## PARKS AND COMMUNITY SERVICES DEPARTMENT

October 18, 2024

**Subject: Grandview Reserve Phase III PUD Development Plan and Preliminary Plan, 2<sup>nd</sup> Submittal (PUDSP-24-001)**

LAND USE REVIEW FILE NO: PUDSP-241

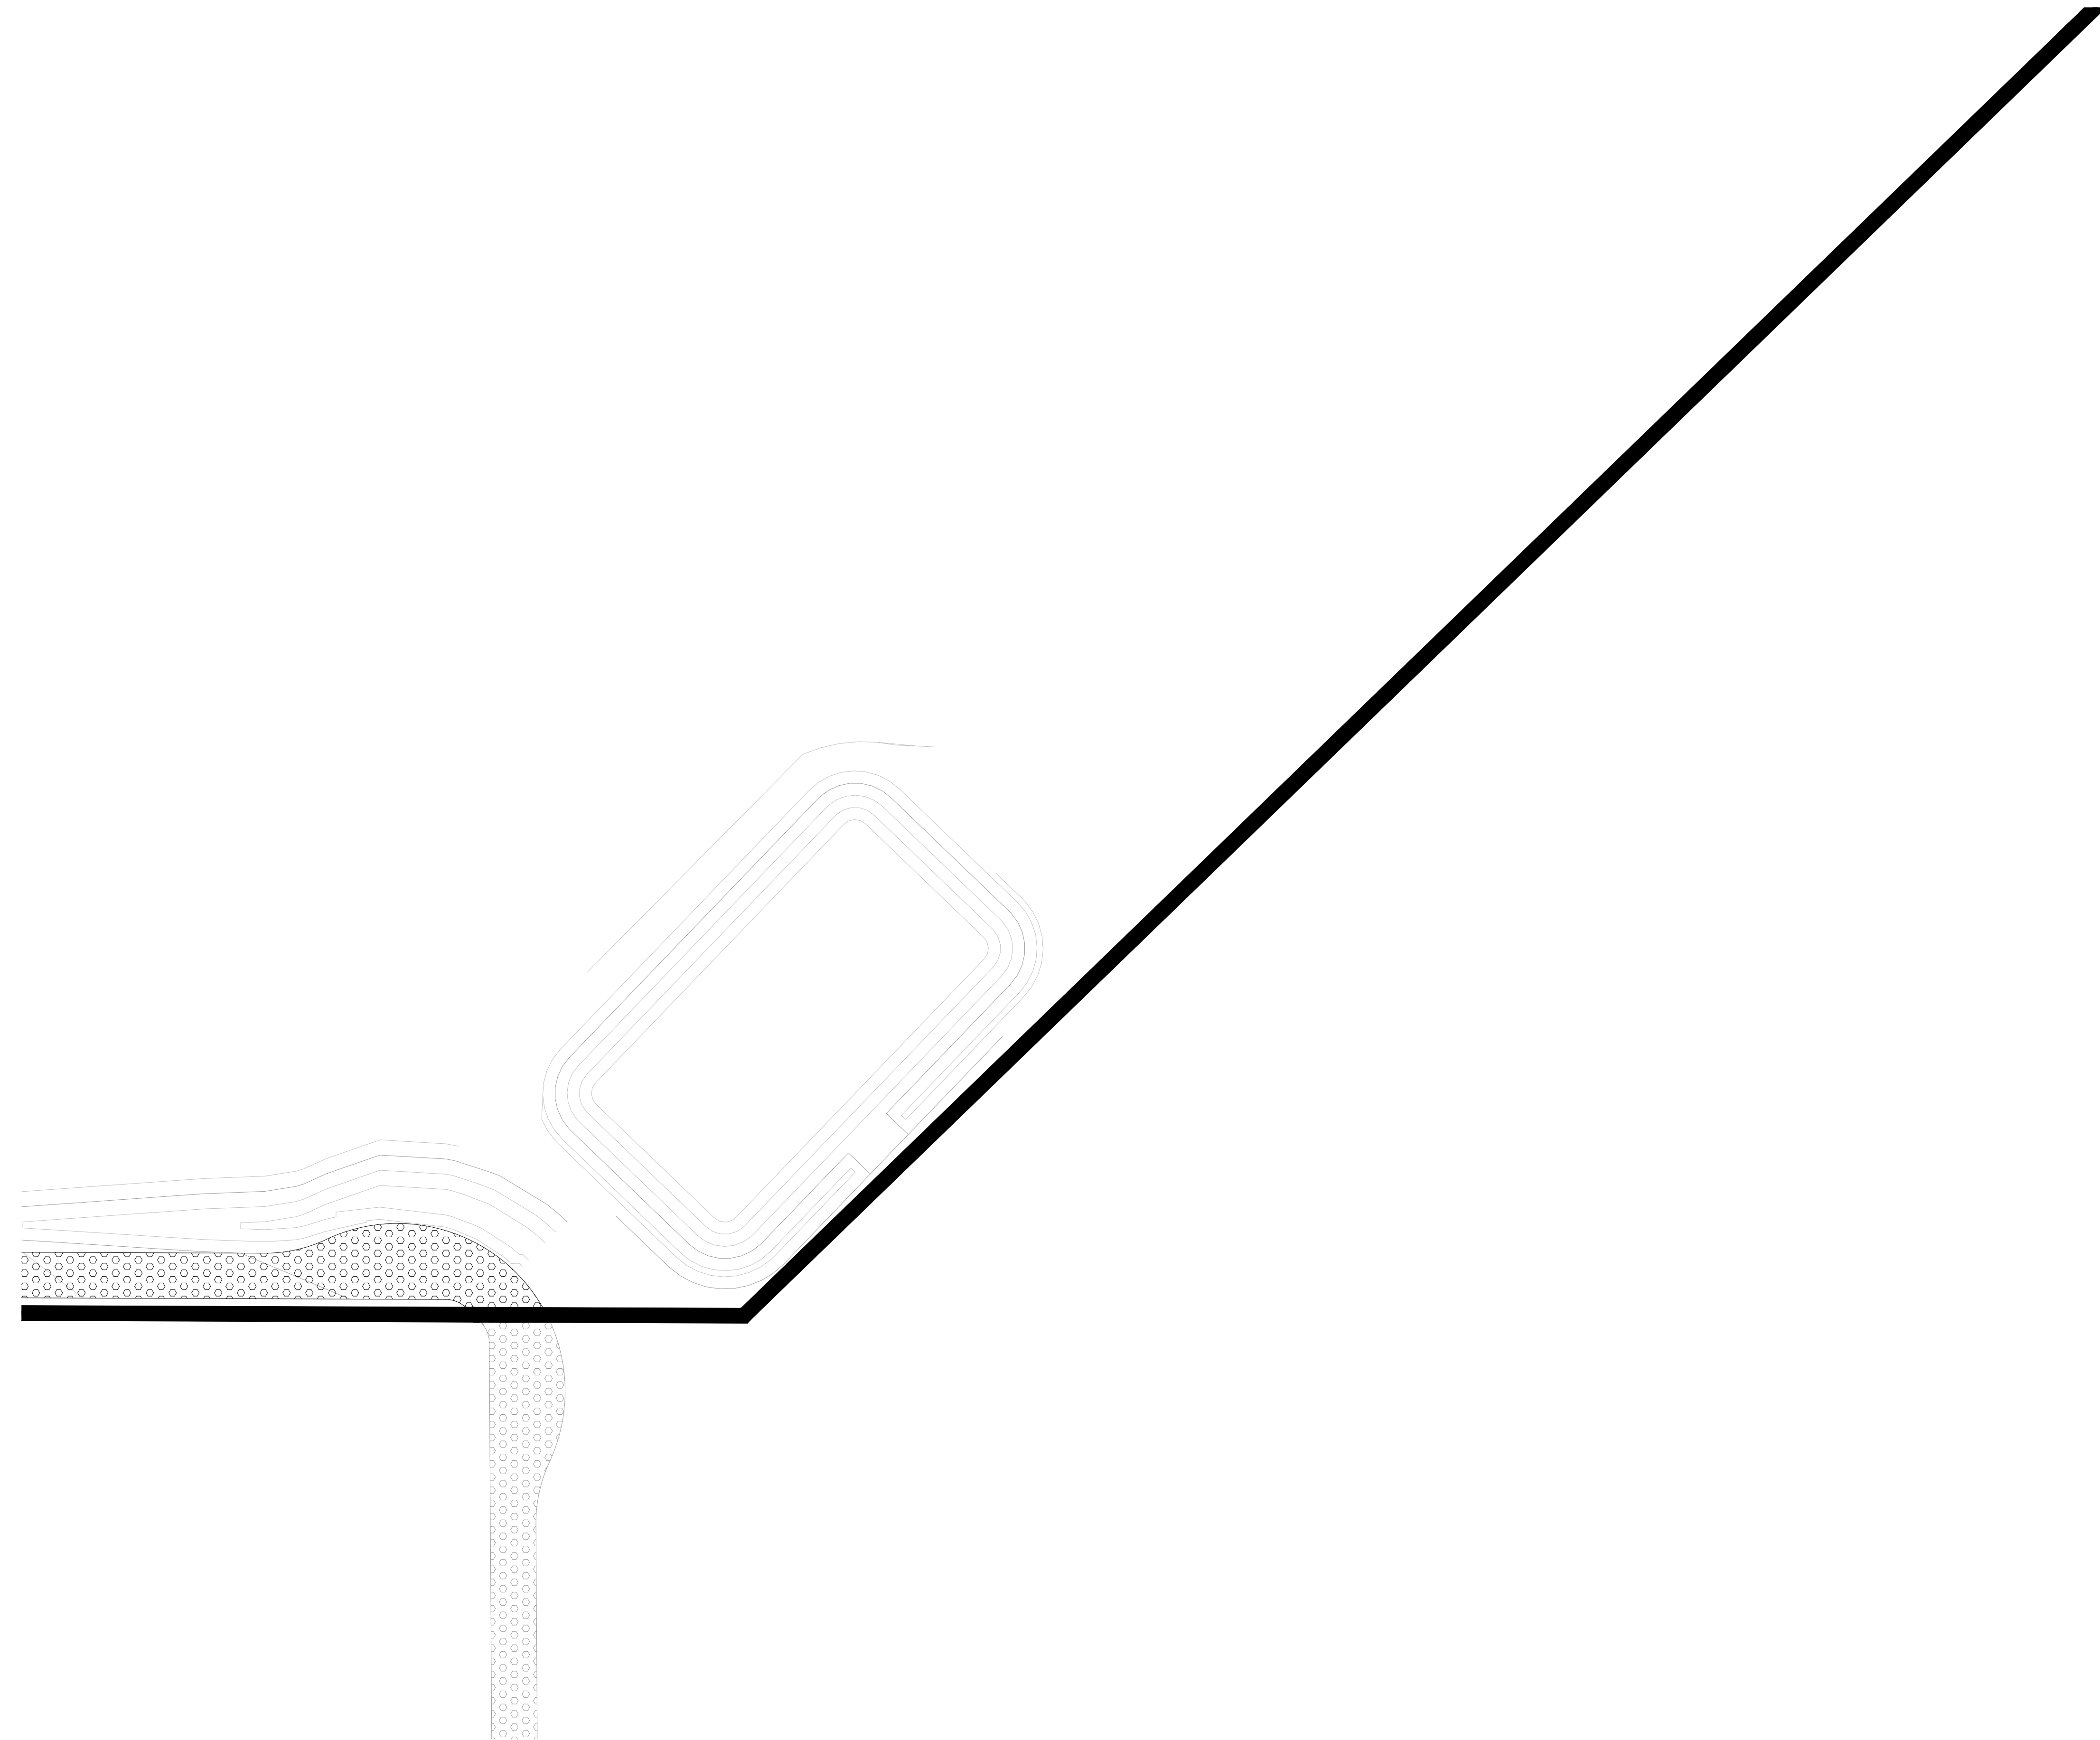
As mentioned, the Phase III PUD Preliminary Plan currently shows approximately 16.78 acres of open space which includes the locations for proposed neighborhood pocket parks in Tracts D and I, common open spaces, an interconnected internal trail network, and various landscape buffers (see highlighted Landscape Plan). Combined, these open spaces constitute approximately 16.3% of the total project area of 102.82 acres, or 21.5% if the 25-acre school tract is not included in the overall project acreage.

EPC staff is encouraged by the applicant's willingness to provide extensive recreational amenities for its residents of Grandview Reserve and citizens of El Paso County through the development of an expansive and connected park, trail, and open space system. Staff recommends that the applicant submit detailed site plans for the proposed neighborhood parks and include multi-generational recreational amenities such as a playground, multi-use turf field,

and/or seating and picnic areas. The submitted Landscape Plans are rather limited and only show half of the proposed park area located in Tract I.
